From: Leighton Matthew <Matt.Leighton@networkrail.co.uk>
Sent: 12 July 2018 11:31
To: Planning
Subject: Ref 6/2018/1519/MAJ - residential development, north of Chequersfield, Welwyn Garden City

FAO – Ms Clare Howe
Ref – 6/2018/1519/MAJ
Proposal – Erection of 30 residential units with associated vehicular access, associated ancillary and enabling works
Location – Land north of Chequersfield Welwyn Garden City

CHEQUERSFIELD, WELWYN GARDEN CITY - CONSTRAINTS PLAN (1:500 A2)
 Dwg No: LSD209-200 Rev: B
 Rev A: Covenant added.
 Rev B: Boundary line amended to suit title plan.

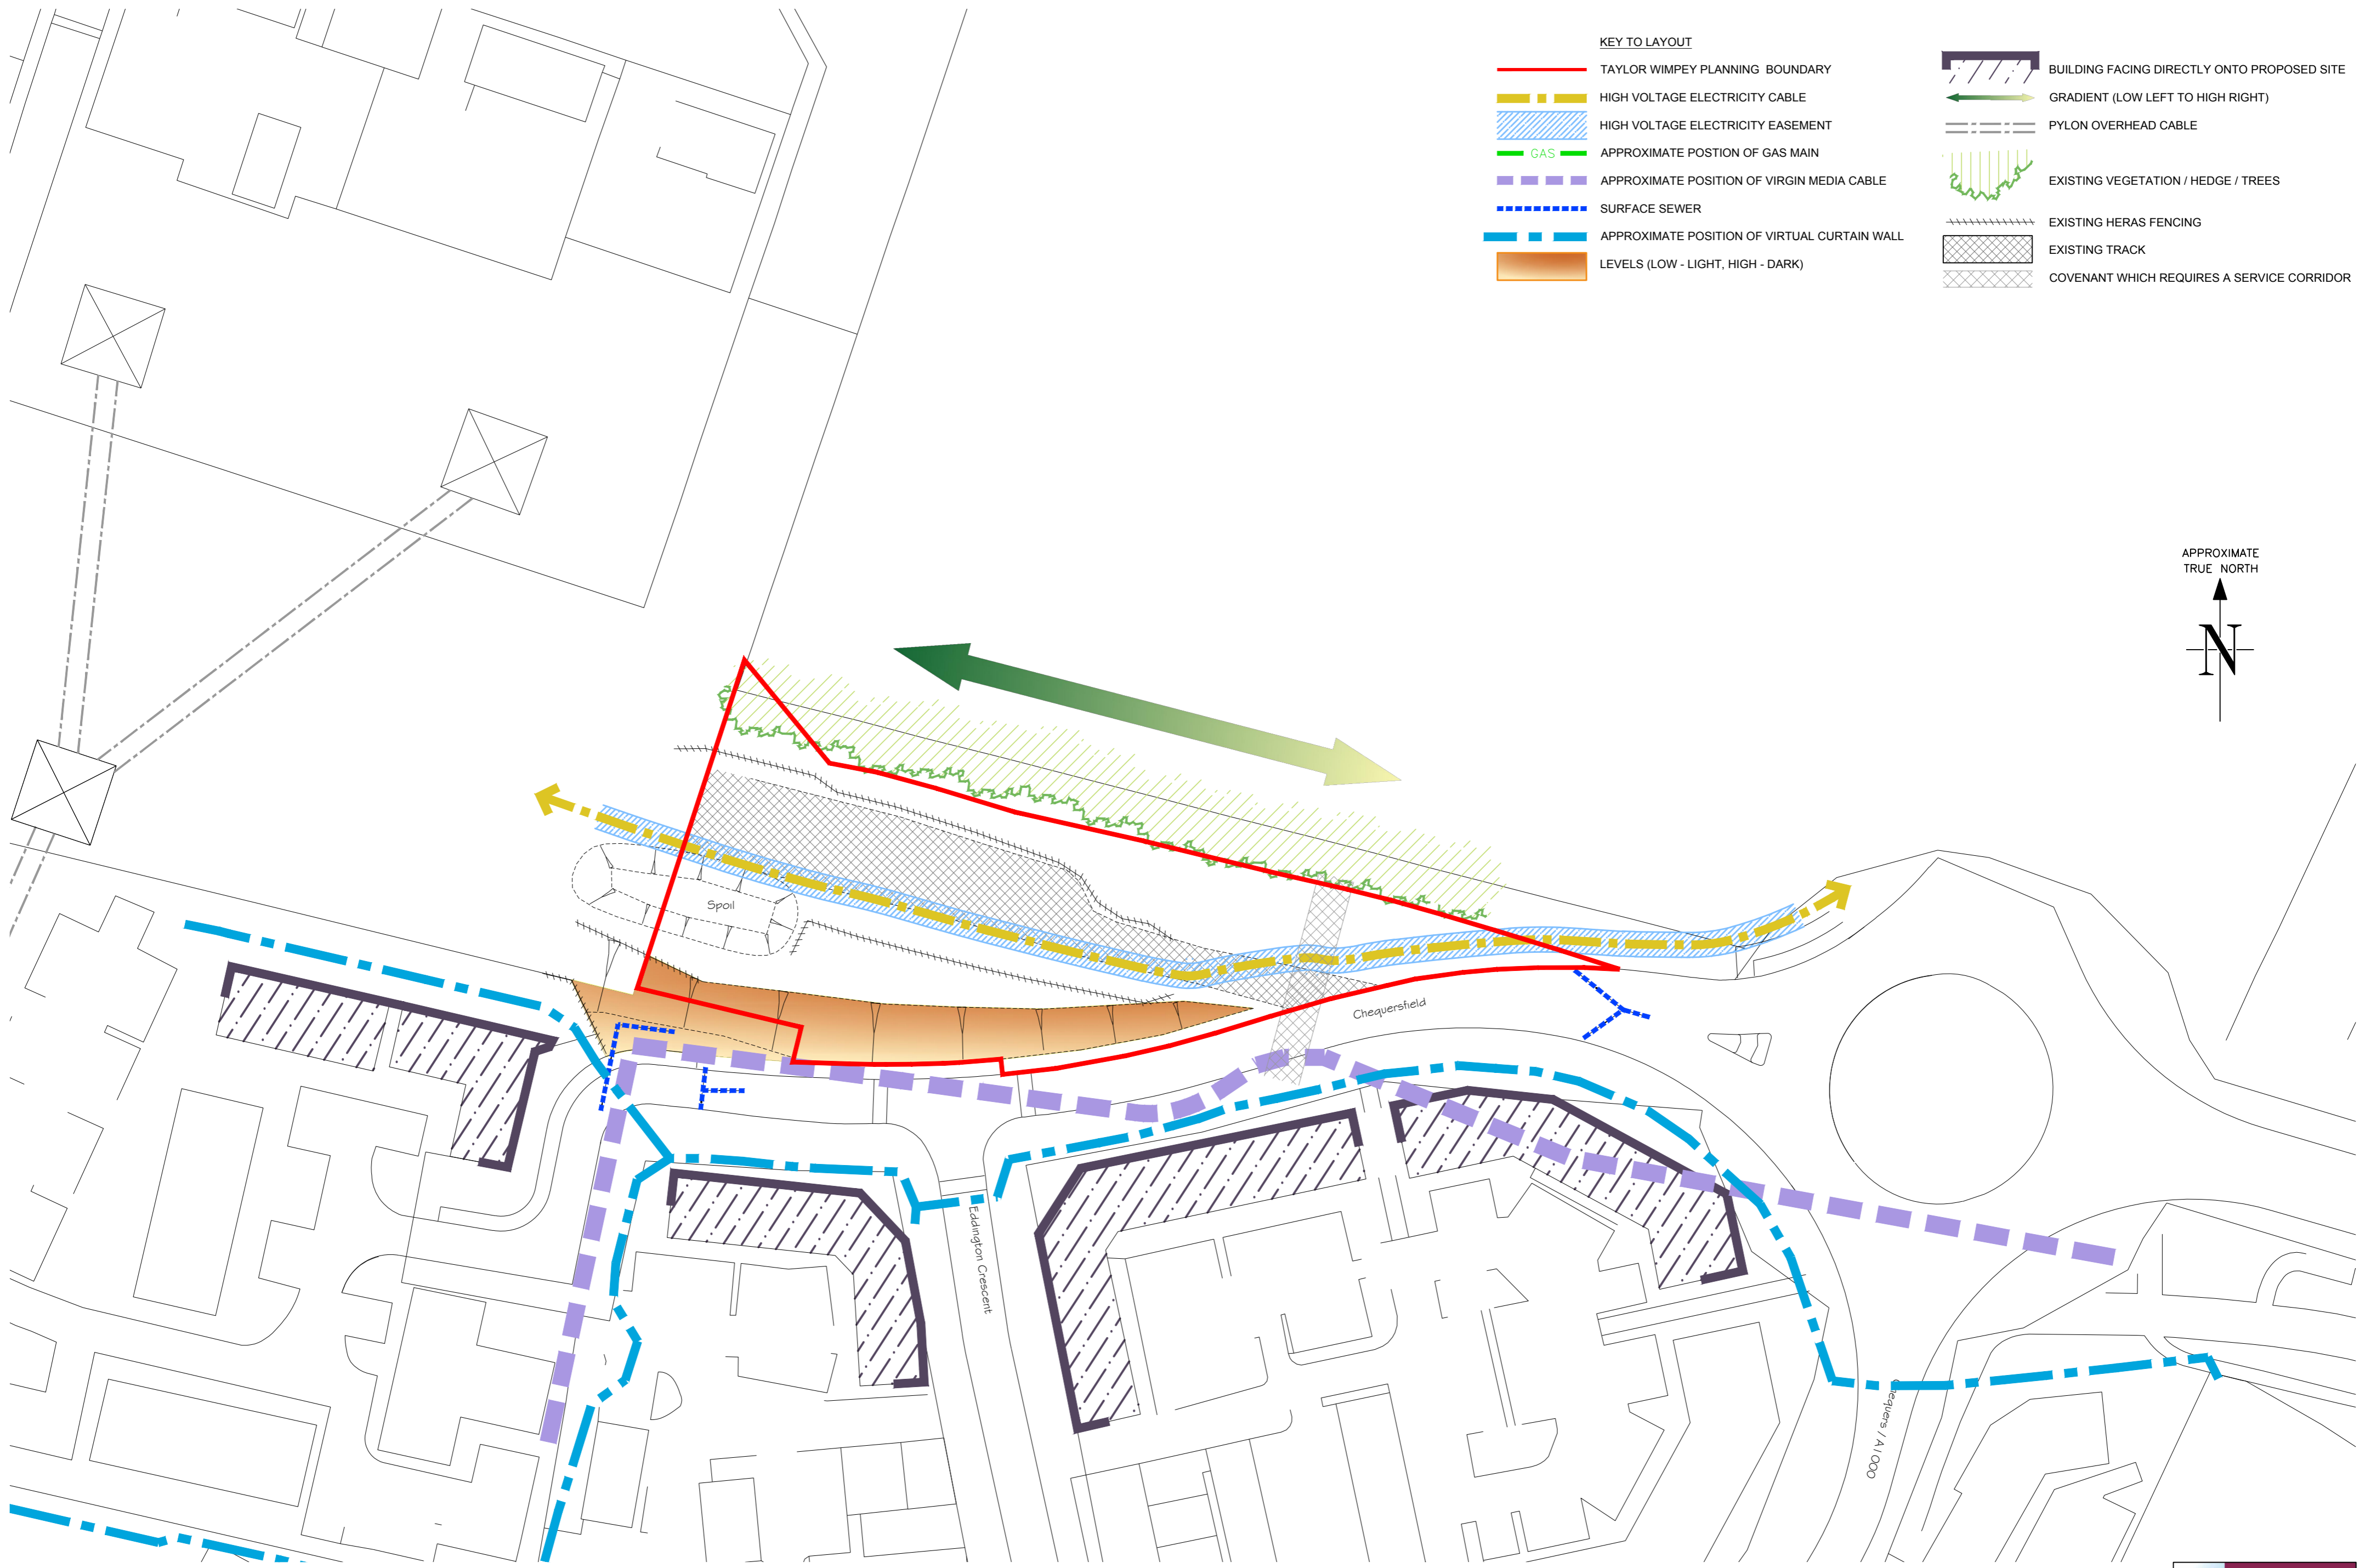
The site is adjacent to the access road for the Borofield Road feeder station which runs along the northern boundary of the proposed development. This is a vehicular access point use of which is essential and is required on a 24/7 basis for ongoing inspection, maintenance and also emergency use. It is imperative that no part of the development, or plant, vehicles or machinery associated with the construction of the development, block or restrict this access at any time. Additionally, use of the access road must remain clear and unrestricted at all times during subsequent use of the site.

All roads, paths or ways providing access to any part of the railway undertaker's land shall be kept open at all times during and after the development. As indicated above, the adjacent railway access road is used on a 24/7 basis and should remain clear and unobstructed at all times, both during construction and during subsequent use of the site.
